Consultation Response from KC, Highways Development Management (HDM)		
2024/90072 land at Bradley Villa Farm, Bradley Road, Bradley, Huddersfield, HD2 2JX		
Discharge of conditions 13 (cycle parking), 14 (electric vehicle charging), 16 (waste management), 33 (air source heat pumps) and 36 (external lighting) of previous permission 2021/92086 for erection of 277 residential dwellings and associated infrastructure and access		
Date Responded: 30/01/24	Responding Officer: A Darwin	Responding Ref: 4-9NW/1

Information has been submitted to discharge Condition 13, 14, 16, 33 and 36 of previous permission 2021/92086 for erection of 277 residential dwellings and associated infrastructure and access. This response considers the information relating to Conditions 13 (Cycle parking) only, which is in the remit of Highway Development Management (HDM).

TITLE:
BIN & CYCLE STORE DETAIL

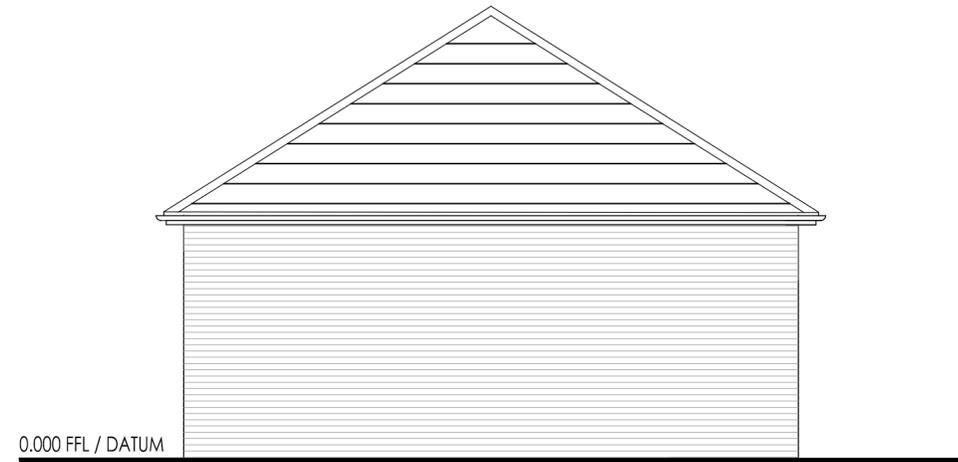
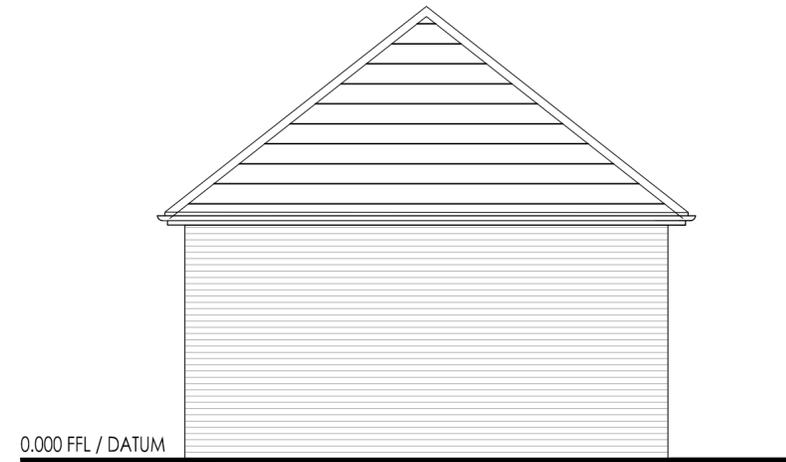
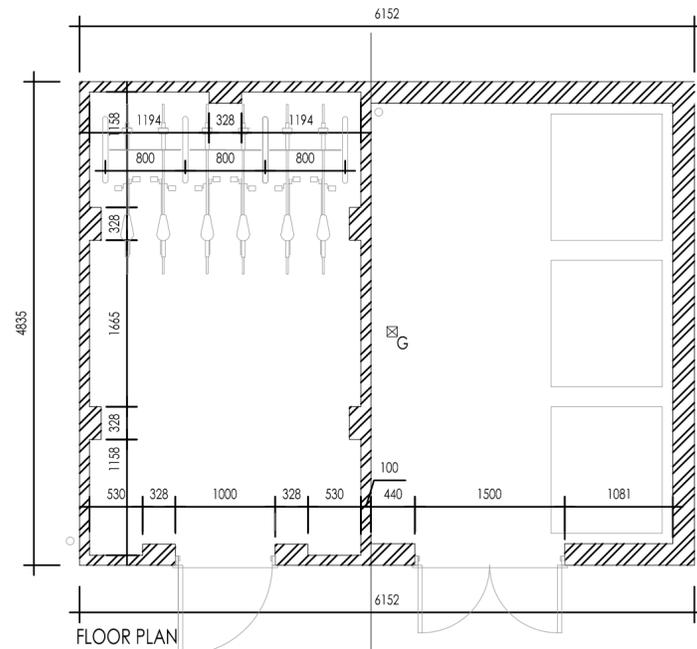
- For the apartment units, communal cycle stores are proposed, which are acceptable in principle. However, the capacity of the cycle store (including dimensions) and the quality of provision (e.g. cycle racks/stand types etc) have not been confirmed. Therefore, further detail of the communal cycle stores are required, which must be inclusive, and cater for a range of bike types (e.g. Min. 5% provision for adapted cycles for disabled users – See LTN 1/20 guidance). It is also noted that there is no path leading to the Plot 204-212 cycle store, which needs to be incorporated.
